Application Correspondence

Subject: RE: Y/140/20/DOC - Cinders Lane Nursery and works to the rear, Cinders Lane, Yapton, BN18 0JJ

Scale : 1:500 @ A1 Date : SEPT 2020
Drawing No : 97_17_103

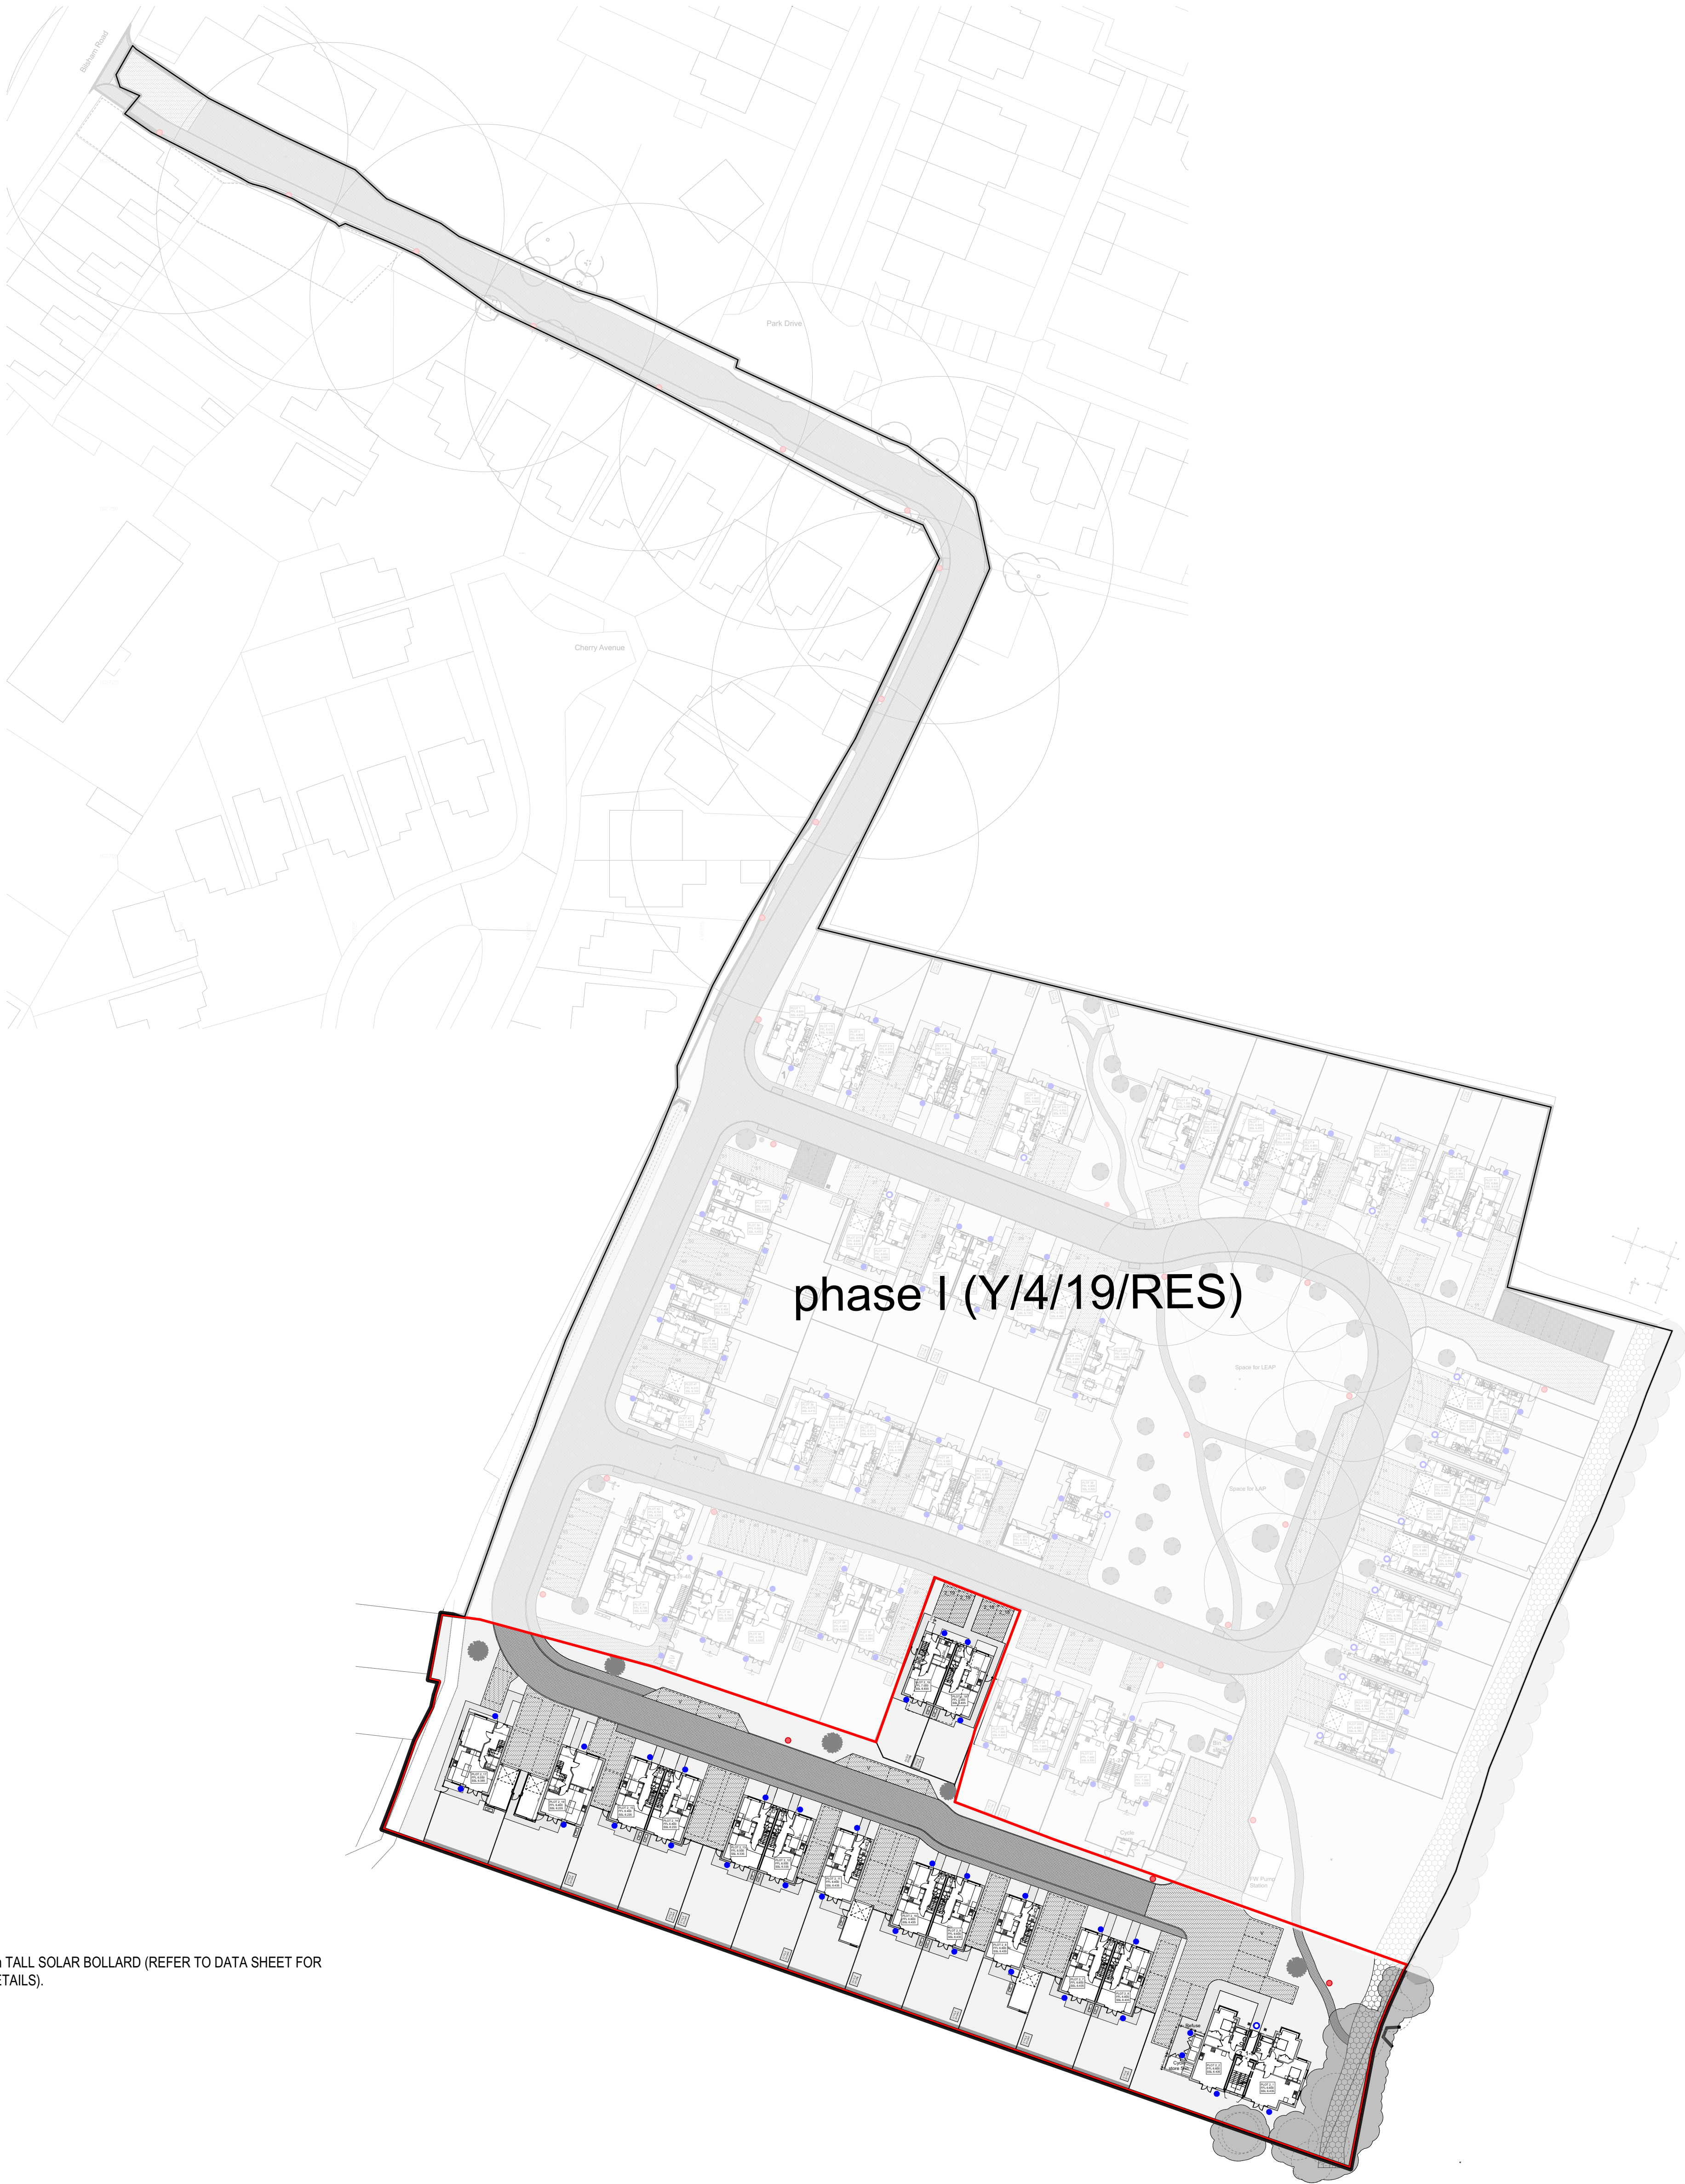
Ref Condition 19; I've spoken with the manufacturer of the proposed solar bollard lights and due to the way the lights operate they are unable to produce a light spill diagram. I would point out though that these are the same bollards that haven't been approved under condition 26 of Y/5/17/OUT (see attached) and therefore it would seem reasonable that they are utilised in this part of the development?

I agree that we have set a precedent with the other approval. I have asked Kate Giddings (EH) to confirm she therefore has no objection.
